Application for a non-material amendment following a grant of planning permission.

Number	108
Suffix	
Property name	
Address line 1	Sea Lane
Address line 2	
Address line 3	
Town/city	Rustington
Postcode	BN16 2RZ
Description of site location must be completed if postcode is not known:	
Easting (x)	504924
Northing (y)	101655
Description

Demolition of existing rear extension and garage and construction of new single storey side and rear extension.

Reference number: R/47/20/HH

Proposed South Elevation (side)
1:100 @ A3

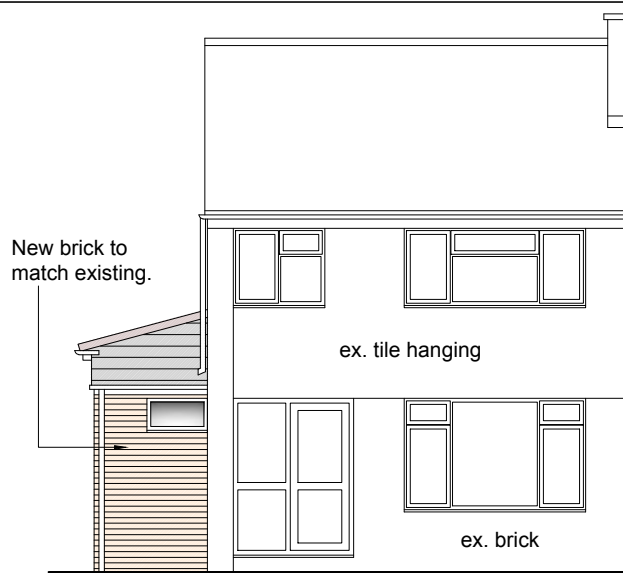
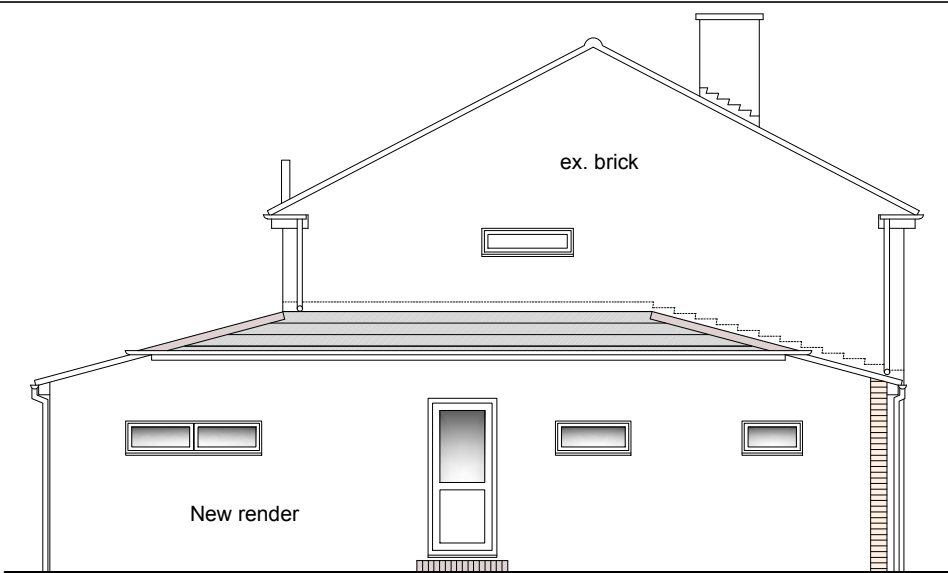
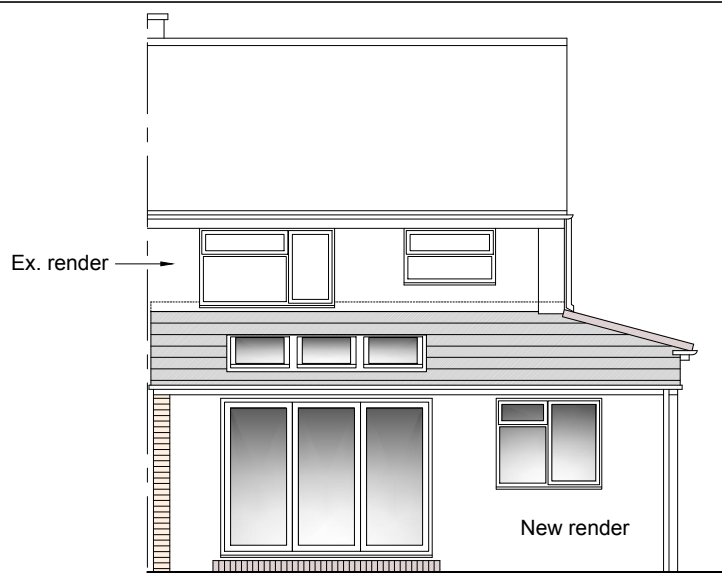
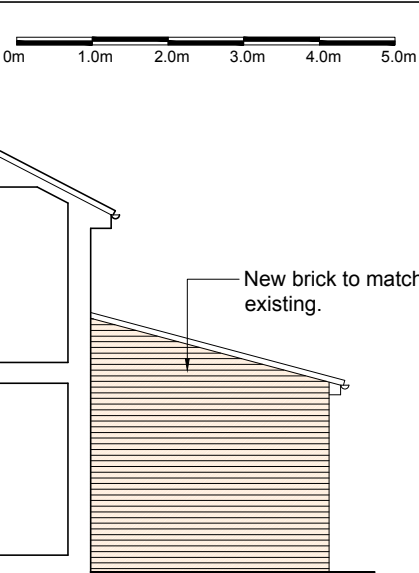
Change of colour to roof material.
Change of wall material to south and west elevations.
Minor alteration to fenestrations.

0308 / 101 rev E
